Please ask for: Nicola Moore
Email: nicola.moore@arun.gov.uk
Telephone: Ext 37944
Our Ref: R/63/22/CLP
Your Ref:
Date: 29th March 2022

Lawful Development Certificate for a Proposed Use or Development

Development: Lawful development certificate for a proposed loft conversion including dormer extension to the rear of the property.

Location: 31 Broadmark Lane Rustington BN16 2HD

DRAWING No:	PL-002	REVISION:	
DATE:	16.04.22	STATUS:	Planning
JOB No:	0008	SCALE:	1:100 @ A3
DRAWN:	GZ	CHECKED:	MF

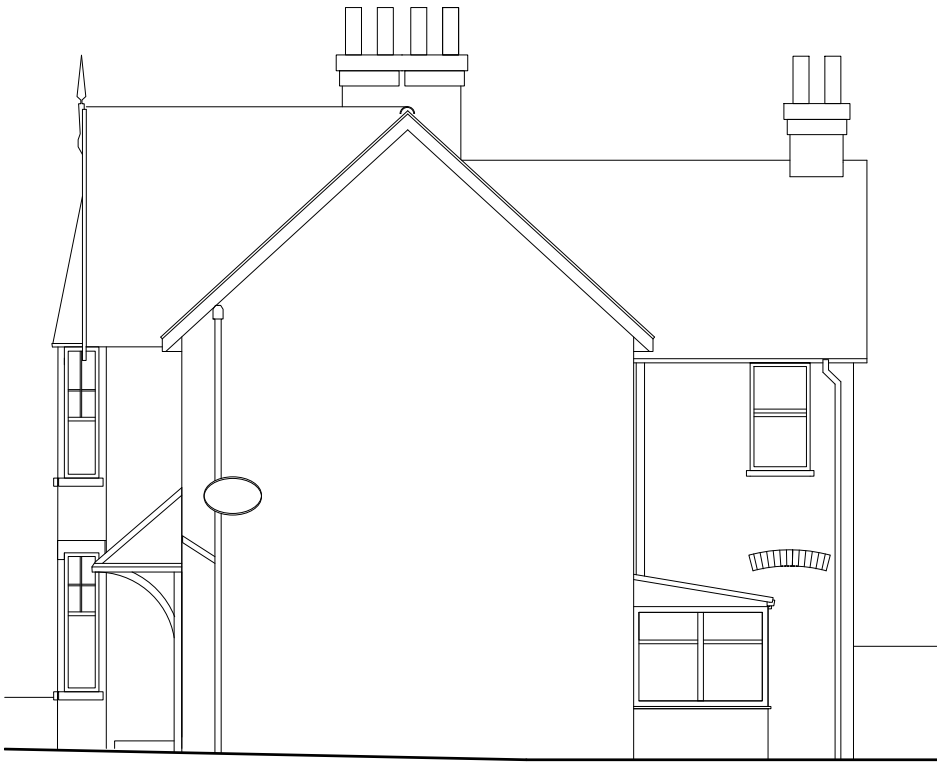
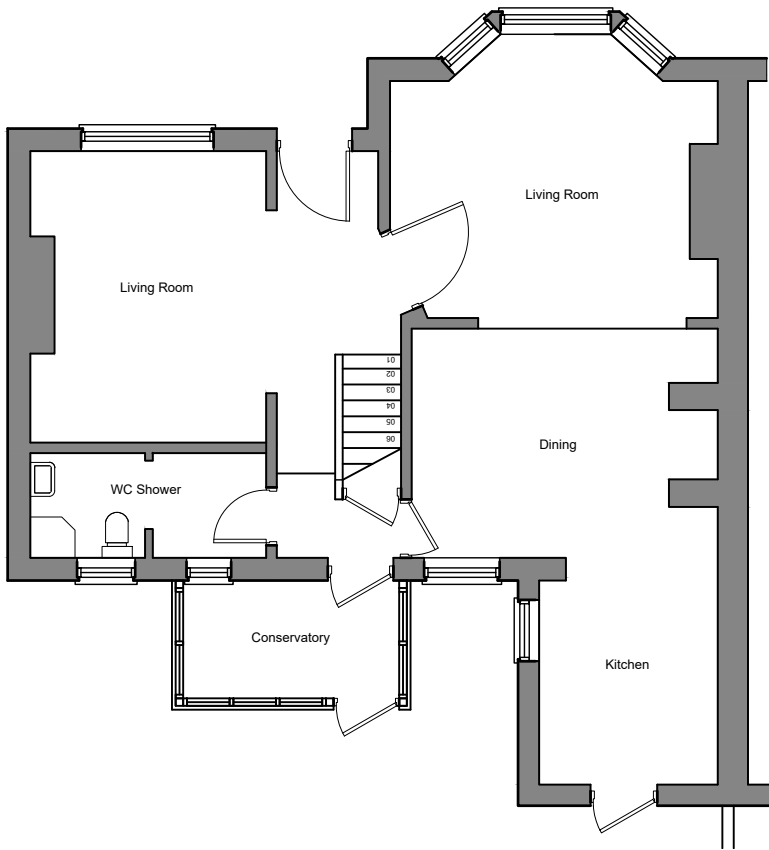
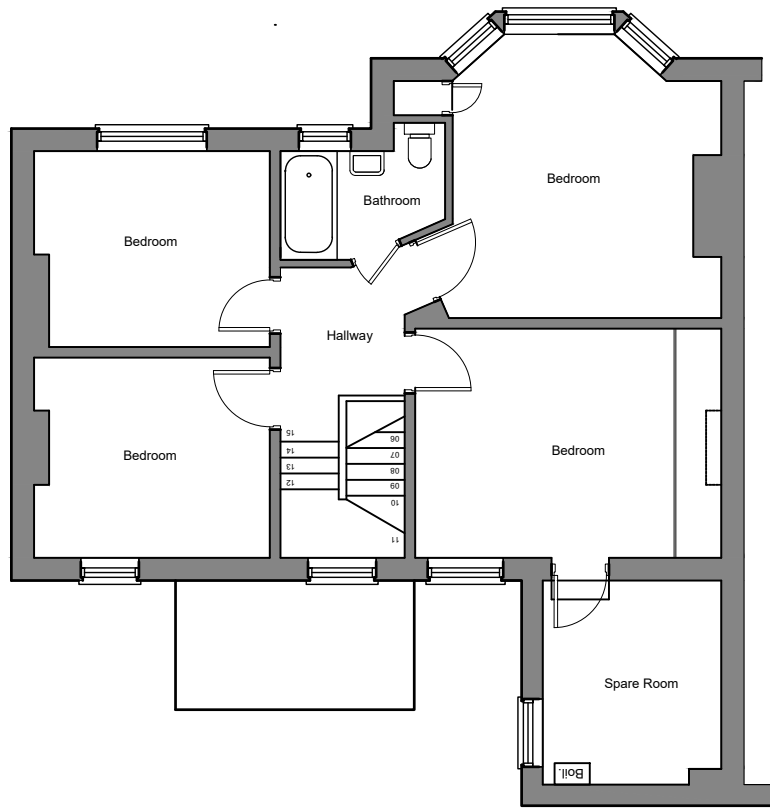
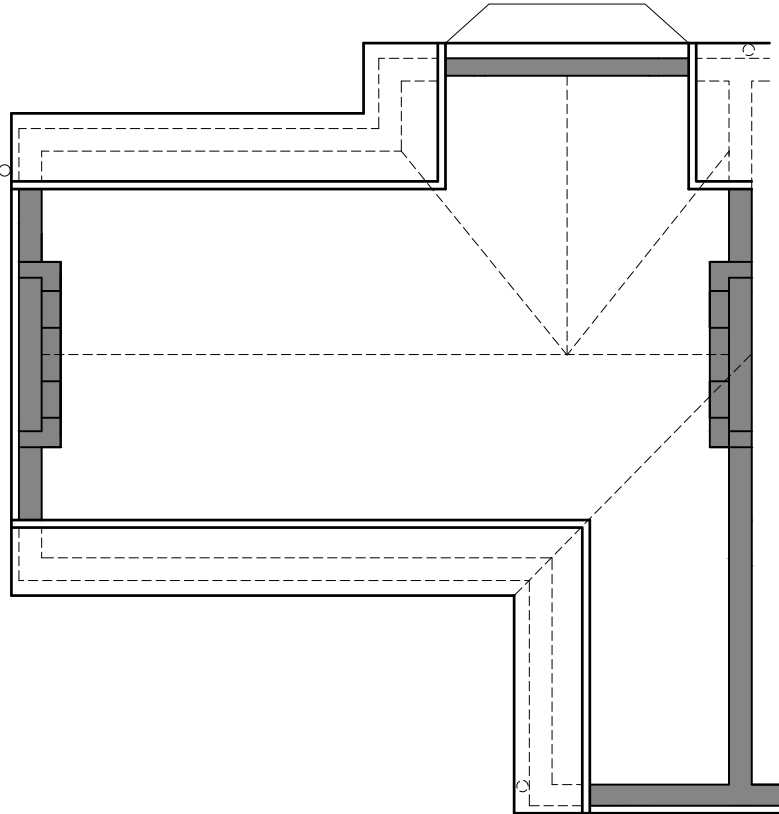
Dwg No PL-002 is titled Location and Block Plans but shows the Existing Floor Plans and Elevations. Please amend accordingly and re submit.
